Our Case Number: ABP-319580-24

Re: Application for permission under Section 37L in relation to further quarry development and continuation of use of the ancillary works and structures under substitute consent application ABP-319397-24 and for the life of the quarry, restoration and rehabilitation of whole quarry site. An EIAR and NIS accompanies this application.
Tromman Quarry, Tromman, Rathmolyon, Co. Meath, A83 DA36.

In accordance with section 132 of the Planning and Development Act 2000 (as amended) you are required to submit, on or before **4th September 2024**, the following information:

Contains OpenStreetMap Data		
Title:Tromman Quarry Location Map		
Scale: 1:50,000 @A4		
KEE-TR/01A		
Drawn By: CST	Date: 21/08/2024

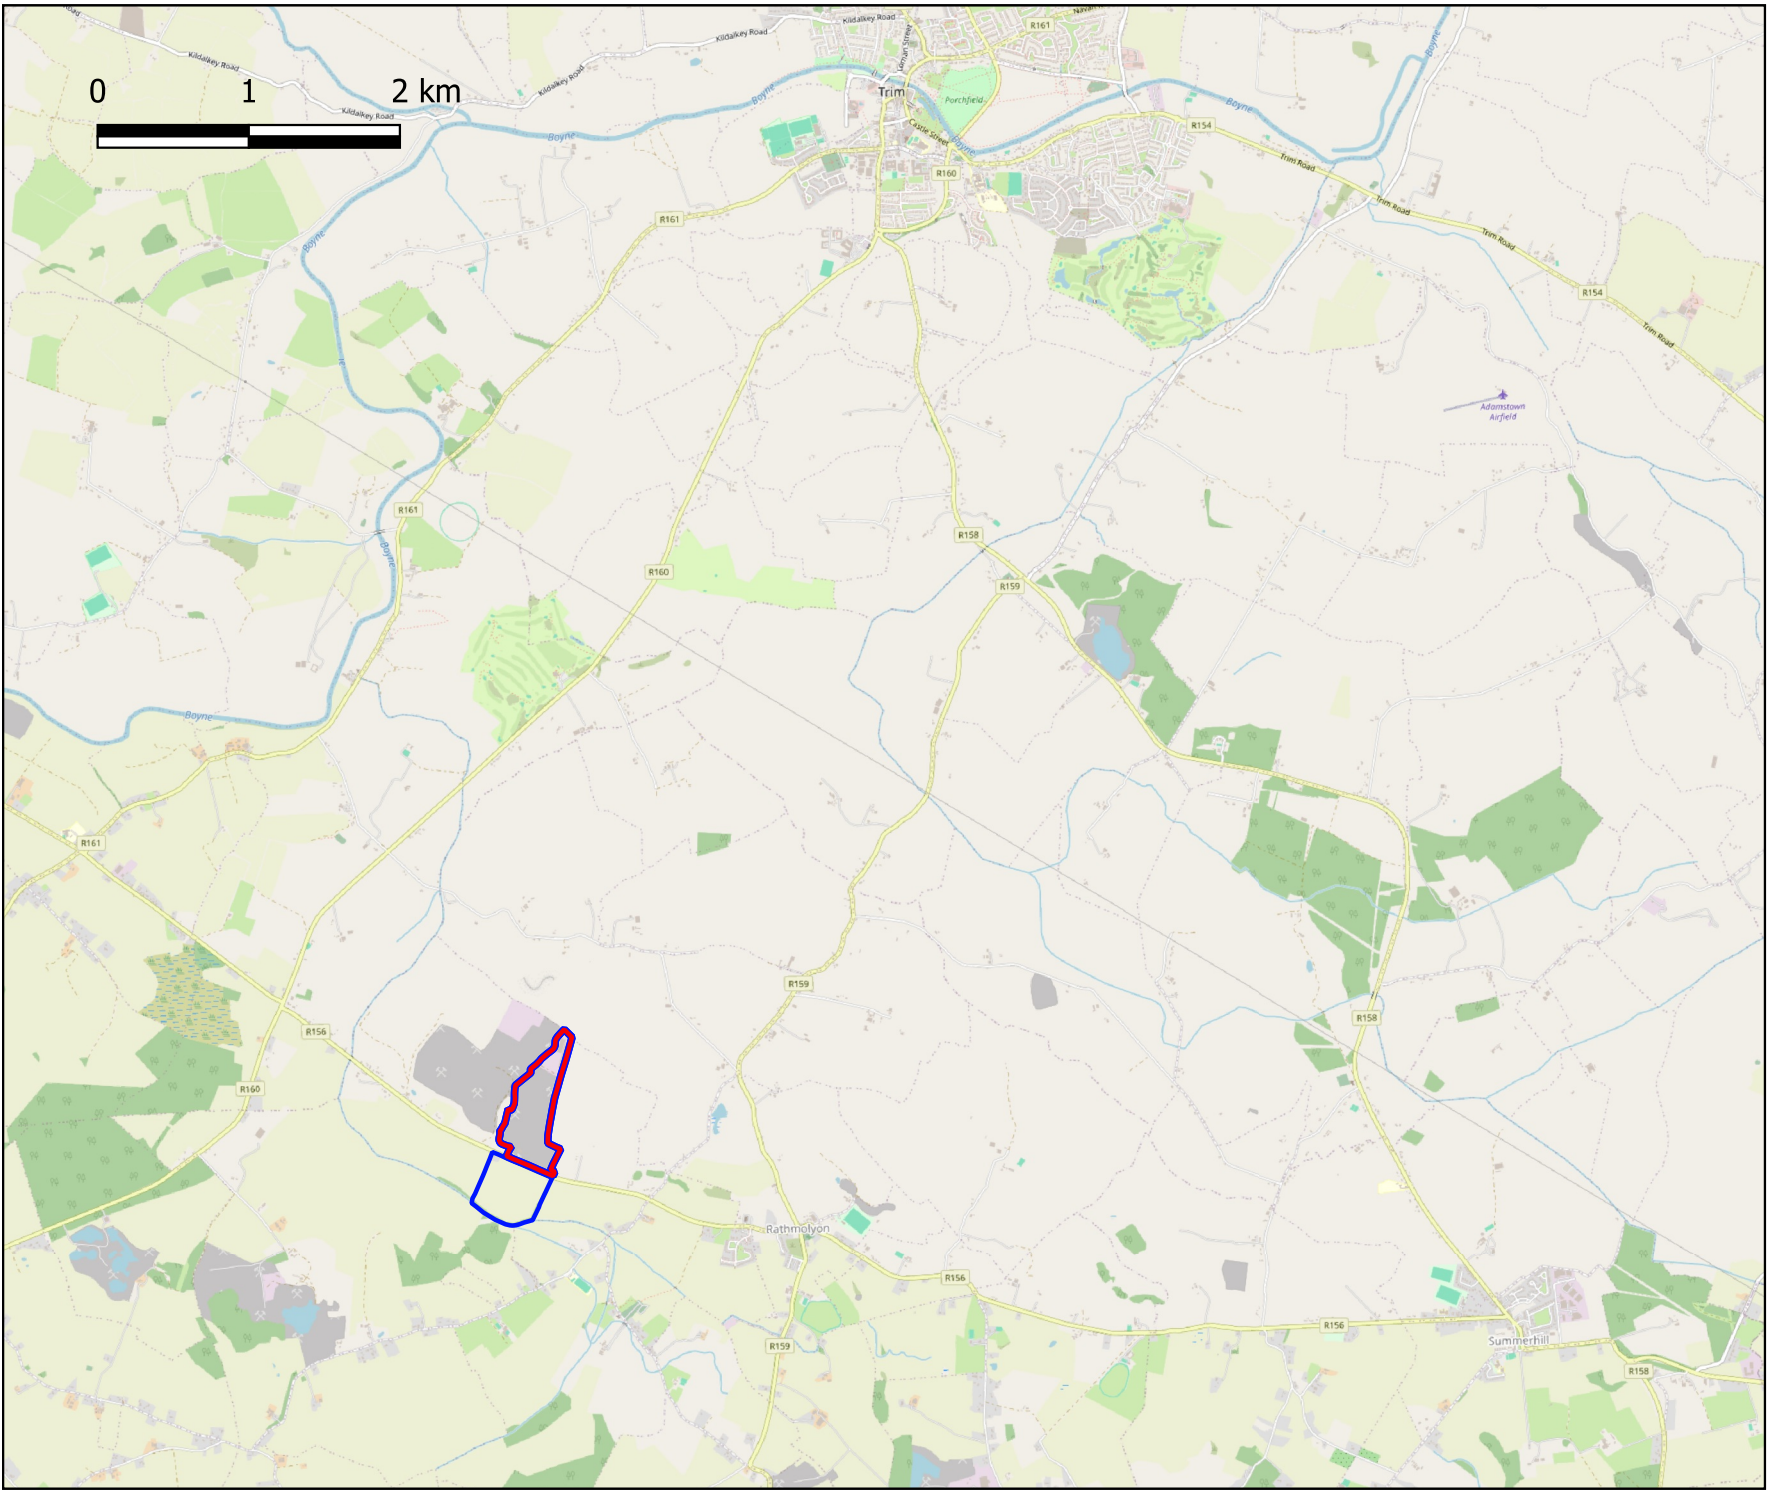
1. **A new site location map to be of sufficient size and containing detail of features in the vicinity such as to permit the identification of the site to which the application relates in accordance with Article 267(2)(b)(c) of the Planning and Development Regulations 2001, as amended.**
2. **A copy of site or layout plans drawn to a scale of not less than 1:500 to ensure all building, roads, boundaries and other features or plant on, adjoining or in the vicinity of the lands are clearly and accurately shown. The plans should accurately reflect the footprint of development. Please note that the site layout plans already submitted do not clearly identify every existing or proposed structure on the lands.**
3. **In accordance with Article 23(1)(f) ensure that the site or site layout plans indicated the distance of any proposed structures from the boundaries of the site.**
